**KIRKLEES METROPOLITAN COUNCIL
INVESTMENT & REGENERATION SERVICE**

**DELEGATED DECISION FOR DISCHARGE OF CONDITION A.4 -
NOTIFICATION OF A PROPOSED ENLARGEMENT TO DWELLINGHOUSE**

Reference no.	2020/HH/90606/W
Site Address	217, Long Lane, Dalton, Huddersfield, HD5 9SG
Description	The proposal is for erection of single storey rear extension. The extension projects 4m beyond the rear wall of the original dwellinghouse. The maximum height of the extension is 2.8m, the height of the eaves of the extension is 2.8m
Recommending Officer	Alice Huxley

DECISION - REFUSED

Ground Floor Plan
1 : 100

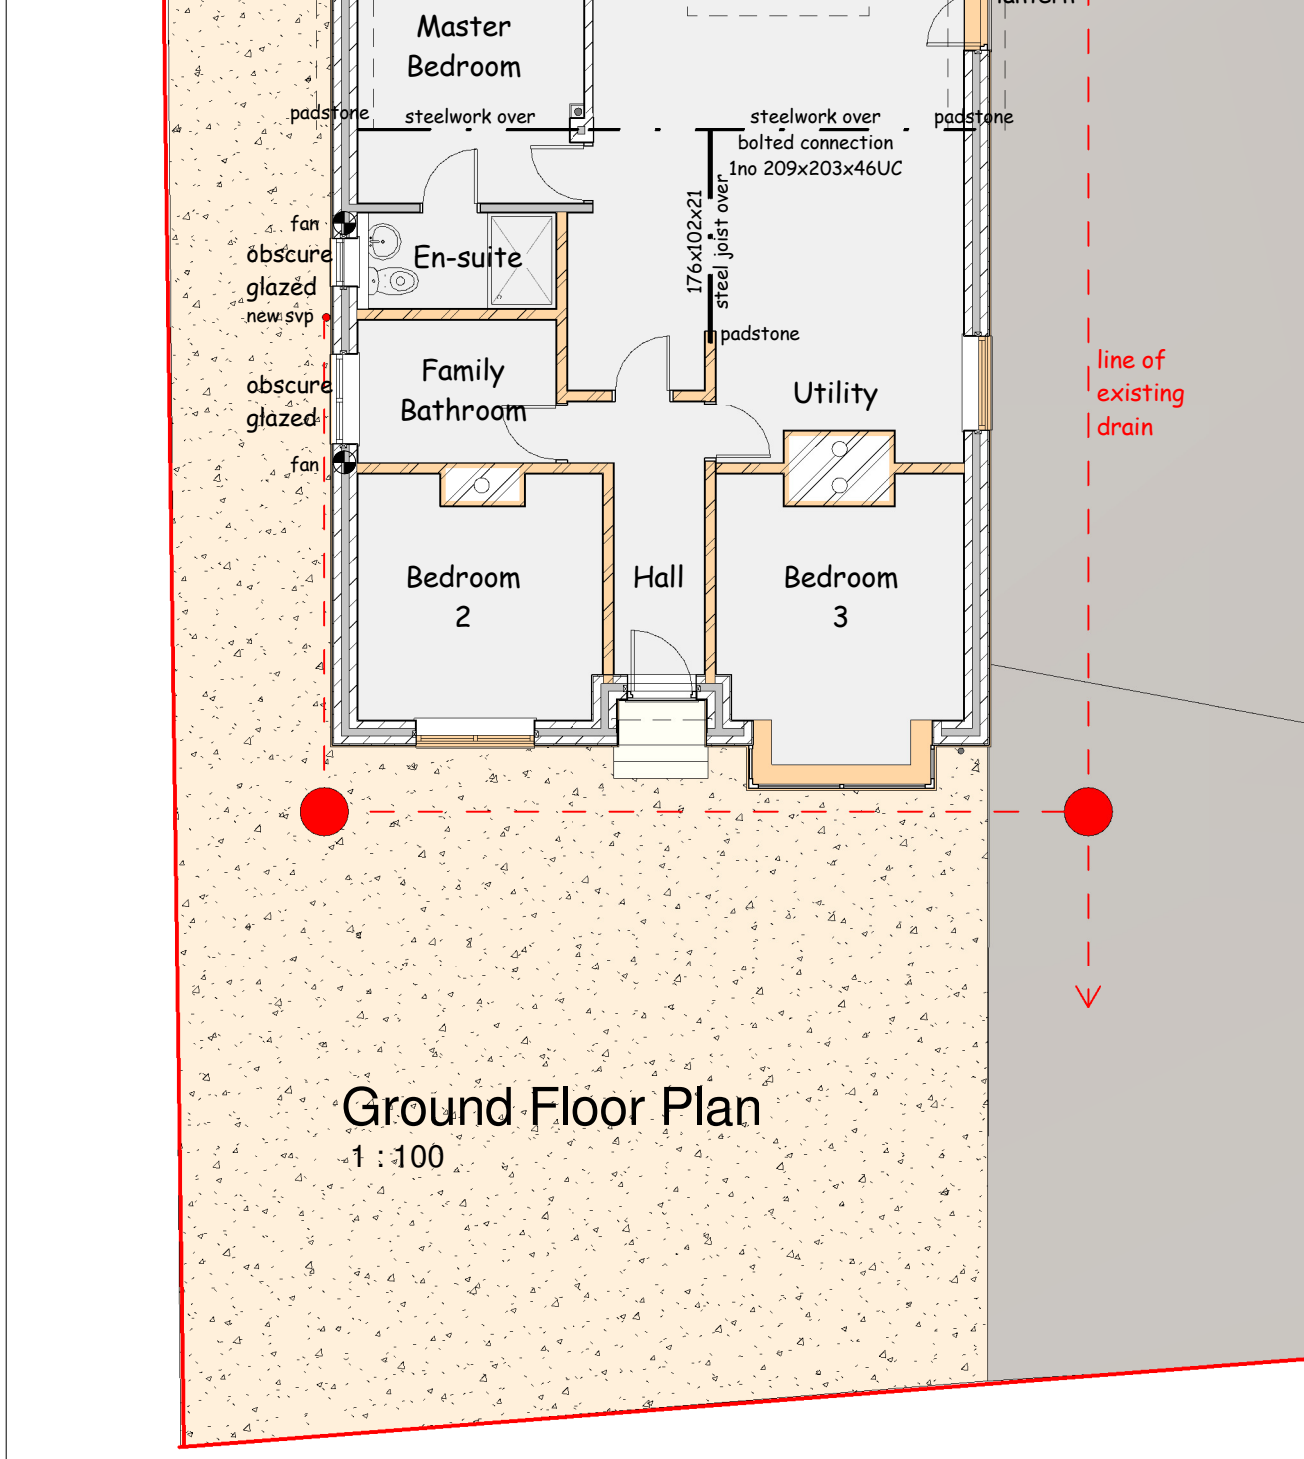
The proposal is for a 4 metre single storey enlargement to the dwelling across the whole rear elevation. Historic maps held by the Local Planning Authority published 1958 show the dwellinghouse largely in its existing form. This is the earliest dated evidence of the dwellinghouse in its original state. This evidence shows the dwellinghouse to include a rear and side projection on the north east corner of the building. This is also evident today. As the materials and design of the projection match the main part of the dwellinghouse and by virtue of historic maps it is considered, on the balance of probabilities, that the rear and side projection was part of the original dwellinghouse. The west elevation of this rear projection is therefore to be considered to form a side elevation of the original dwellinghouse when having regard to Government Technical Guidance for Permitted Development rights.

The proposed extension projects beyond this side elevation and has a proposed width along the whole rear elevation. As such the proposed enlargement extends beyond a side elevation of the original dwellinghouse and has a width greater than half the width of the original dwellinghouse contrary to paragraph (j)(iii) of Part 1, Class A of Schedule 2 of the Town and Country Planning (General Permitted Development)(England) Order 2015 (as amended).
